Application Reference: 2026/0262

Site Address: 1 Harvest Close, Worsbrough Bridge, Barnsley, S70 5AY

This application seeks full planning permission for the erection of a two-storey side extension, with a drive through carport at ground level.

**TITLE**  
DRAWING SHOWING PROPOSED ELEVATIONS

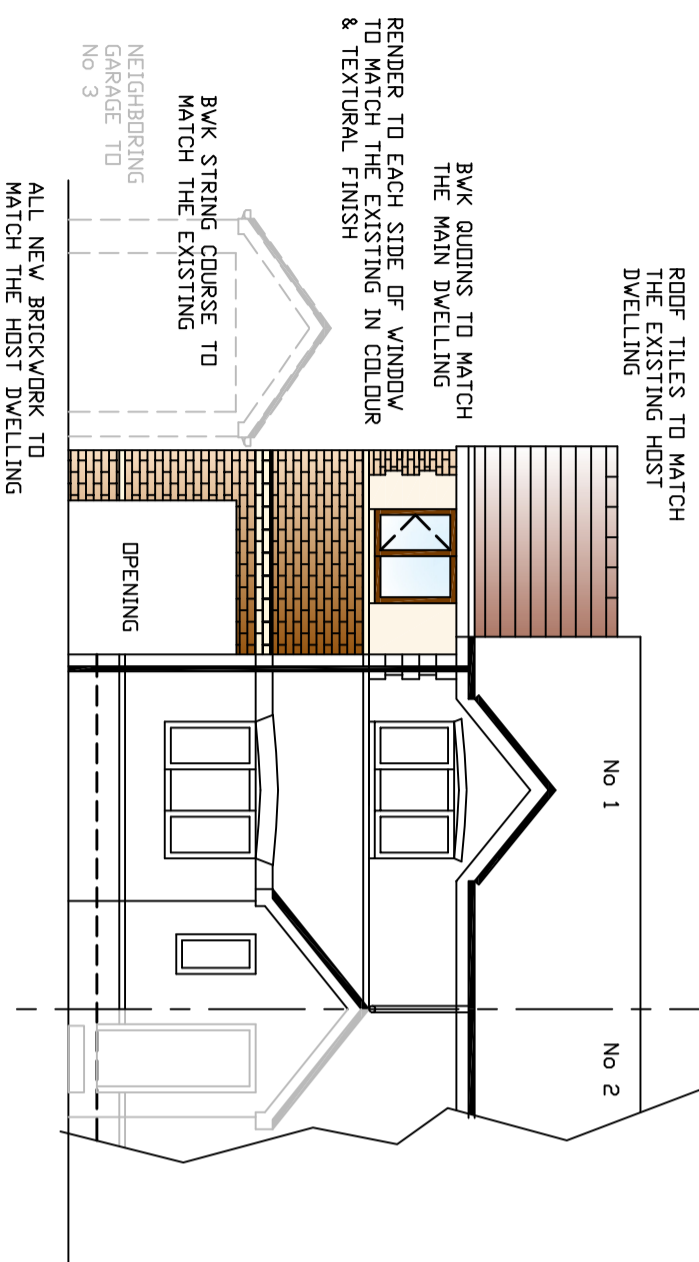
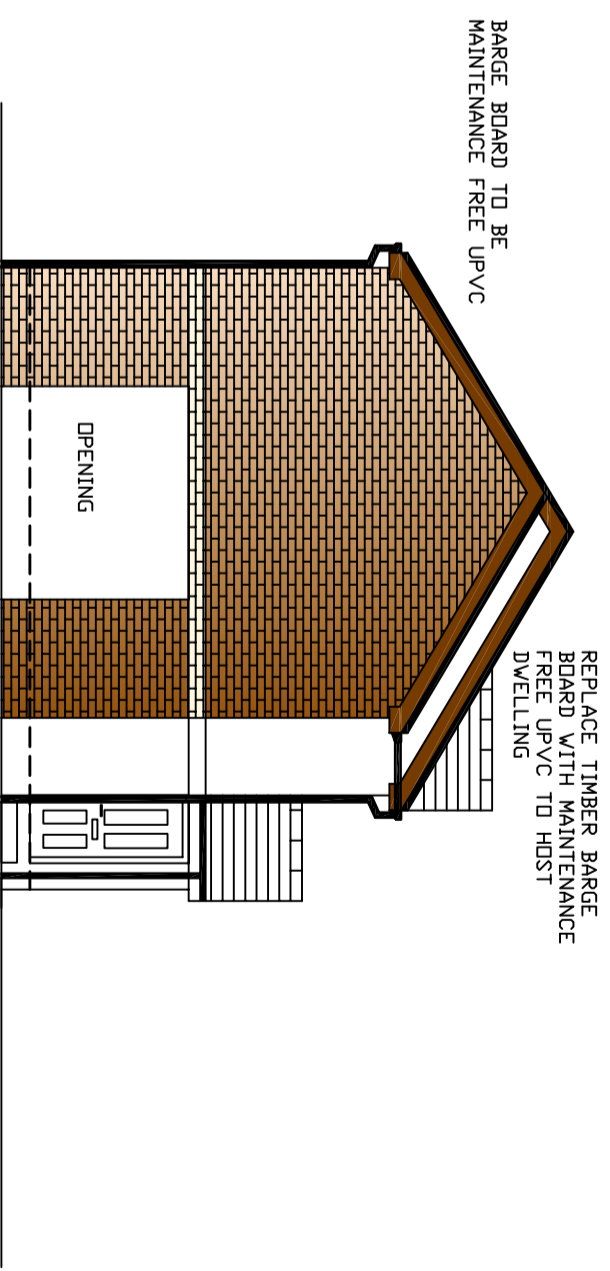
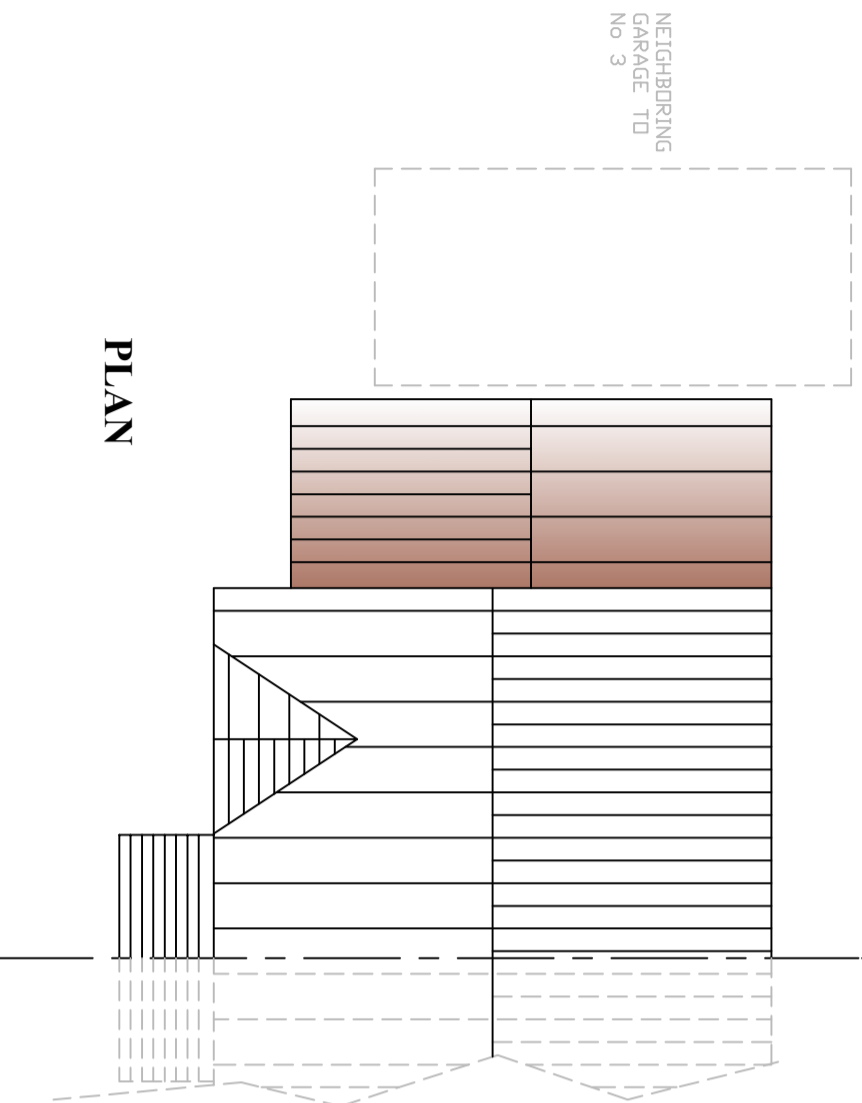
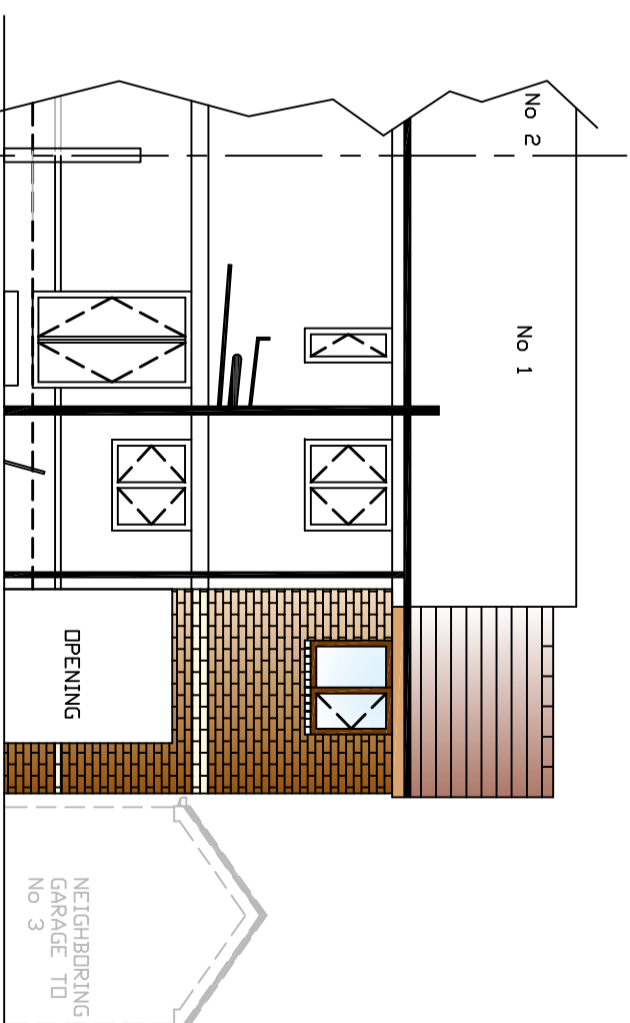
The SPD advises that a separation distance of 12m should be maintained between a blank gable wall and habitable room windows on existing properties. The proposed extension would be located at 90 degrees to the property to the south, 3 Millers Dale, and would be located approximately 11m from the rear elevation of this property. It is acknowledged that the development falls slightly short of the required separation distance. However, it is not considered that the shortfall would lead to a detrimental loss of outlook from this property to the detriment of residential amenity. This carries limited weight against the application.

Supplementary Planning Document House extensions and other domestic alterations states that 'the design of a two-storey side extension should reflect the design of the existing dwelling in terms of roof style, pitch materials and detailing and should not have an excessive sideways projection, i.e. more than 2/3 the width of the original dwelling'. In this instance the proposed extension projects 2.7m from the side elevation and therefore complies with the guidance set out in the SPD.

The document also states that a two storey side extensions should have a set back from the front elevation by at least 500mm, to allow for a vertical break in the roof plane, a lowering of the ridge line and to reduce the terracing effect, the set-back also lessens the unsightly bonding of old and new materials. It goes on to state that the linking or closing the gap between semis or detached houses to give the effect of a terrace, is a detrimental change to the character of the street scene and must be avoided, therefore a side extension should also be set in by one metre from the side boundary with an adjacent property, to further avoid the terracing effect.

The proposed extension is located up to the side boundary, however it is not considered to lead to a terracing effect due to the neighbouring property to the south being located at 90 degrees to the application site. In addition, the proposal incorporates a set-back of 1m from the front elevation; this carries considerable weight in favour of the application.

As mentioned previously, the dwelling benefits from a small mansard roof, the applicant could change the design of the original roof to pitched roof, by undertaking a hip-to-gable extension which would not require planning permission. The change to a full gable wall has been indicated on the submitted plans. The proposed two storey side extension has therefore been designed to match this change rather than that of the existing dwelling.

The design of the proposed side extension relates well to that of the original dwelling in terms of roof style, pitch and detailing and the materials proposed, in addition the fenestration of the proposed matches that of the original dwelling. This carries considerable weight in favour of the application, and it is therefore considered that the proposed extension is acceptable in terms of visual amenity and in compliance with Local Plan Policy D1.

PROPOSED FLOOR LAYOUTS

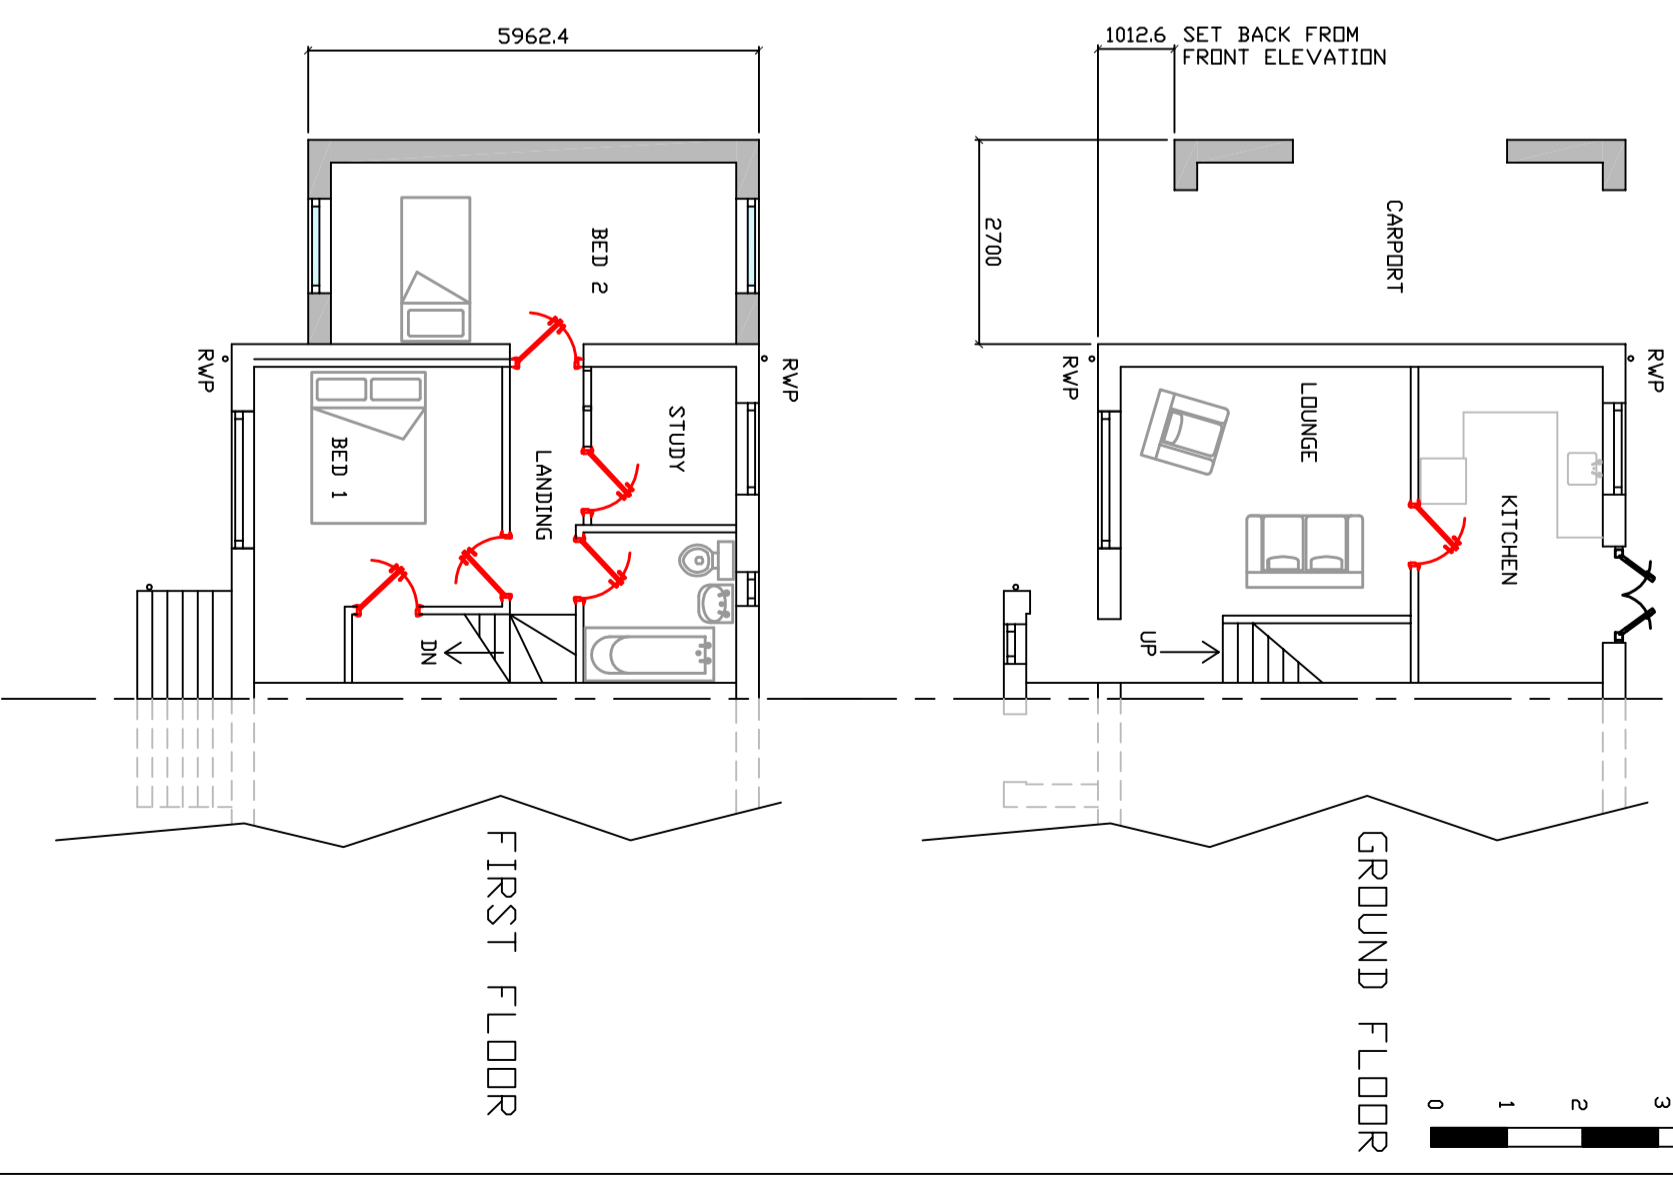
No habitable room windows are proposed within the side elevation of the proposed extension and the windows located on the front and rear elevations do not project closer to the respective boundaries than the existing dwelling. As such the proposal would not increase levels of overlooking to an unreasonable level; the carries considerable weight in favour of the application.

The proposed development would not result in the requirement for additional off-street parking provision; the proposal would however be located on the existing driveway potentially resulting in the loss of off-street parking. The plans submitted indicate that the area to the front of the car port is of a sufficient length to accommodate a vehicle, which is clear from the planning officer site visit photos. Therefore, there is no loss of off-street parking provision; in addition, there are no on-street parking restrictions to the front of the property. This carries significant weight in favour of the application. The development is therefore considered acceptable in terms of its impact on highway safety and complies with Local Plan Policy T4 New Development and Transport Safety.
